Current Zoning: N1-A (Neighborhood 1-A)
Proposed Zoning: N2-A(CD) (Neighborhood 2-A, Conditional)

Approximately 32.35 acres located east of Trevi Village Boulevard, south of North Tryon Street, and west of Hudspeth Road.

The petition proposes the development of up to 190 multi-family attached dwelling units. The site is currently developed with 2 single-family houses.

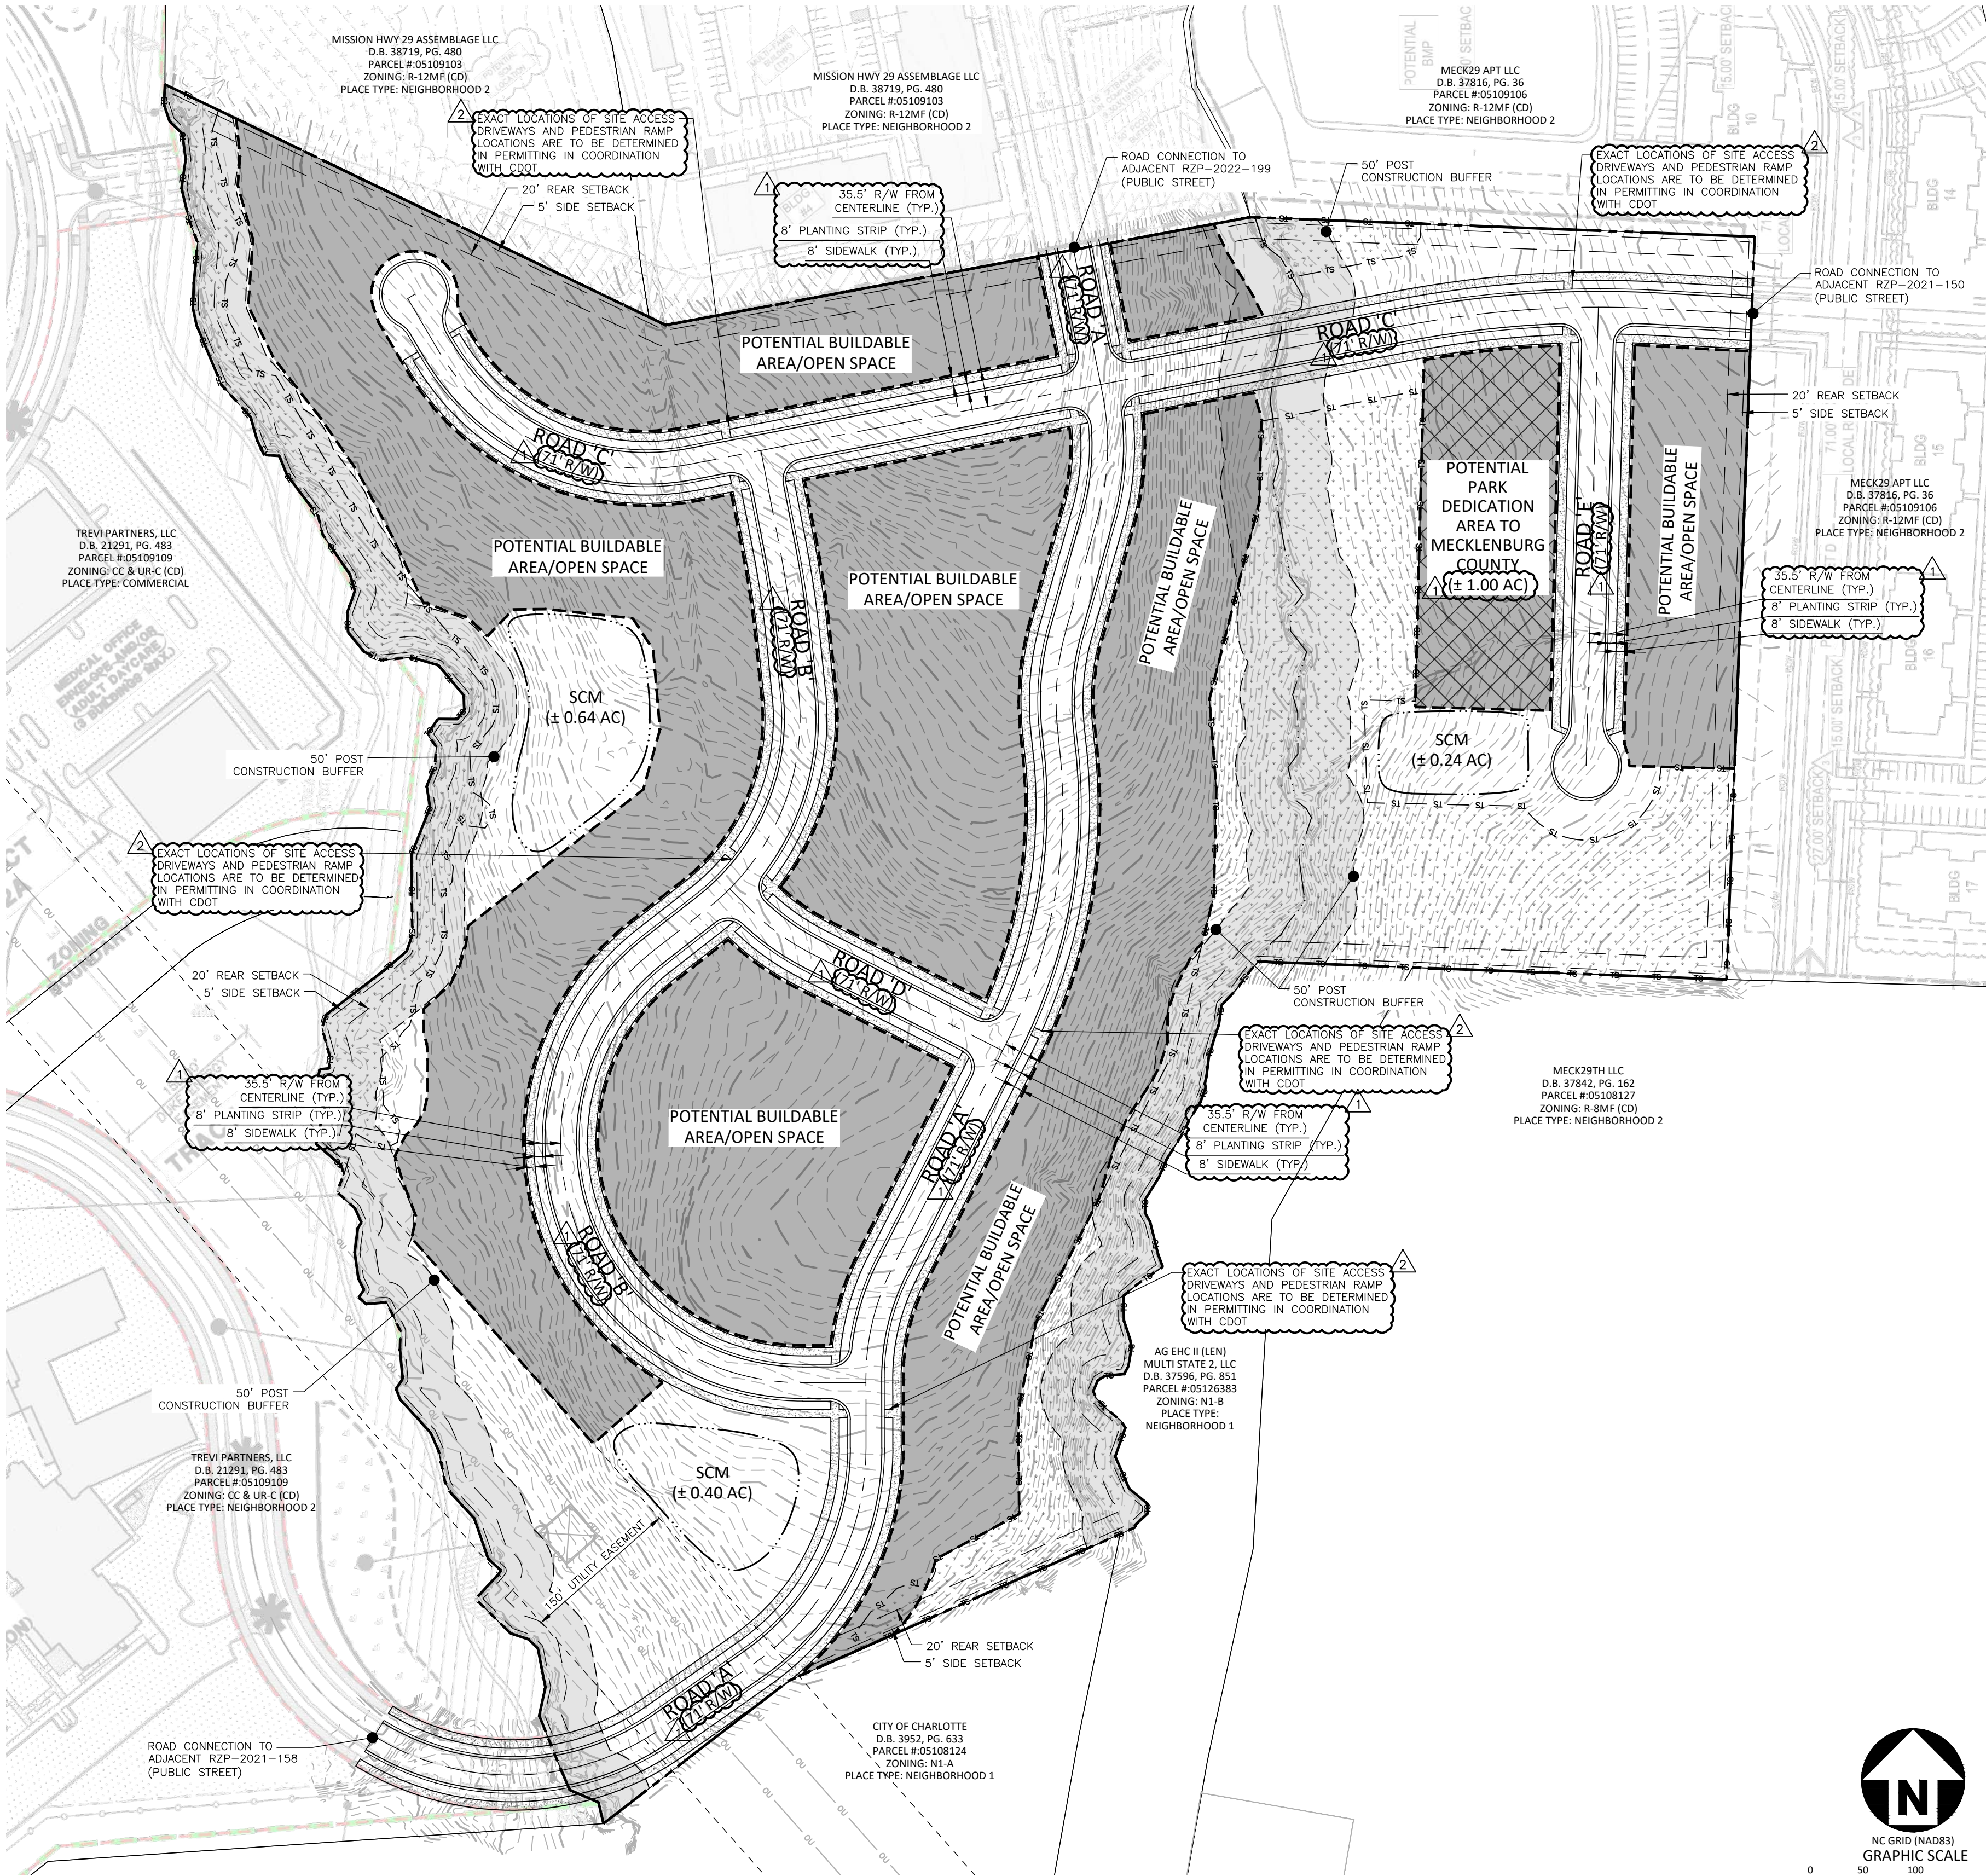
1. Show additional ramps at the intersections within the site plan.
2. Revise site plan and conditional note(s) to commit to a roadway stub to St. Margarets Way in coordination with subdivision. Site plan shall label and dimension from roadway centerline.

3. The boundary/tree save line does not match the property line. Accurately show the property line.
4. Define and quantify enhanced plantings.
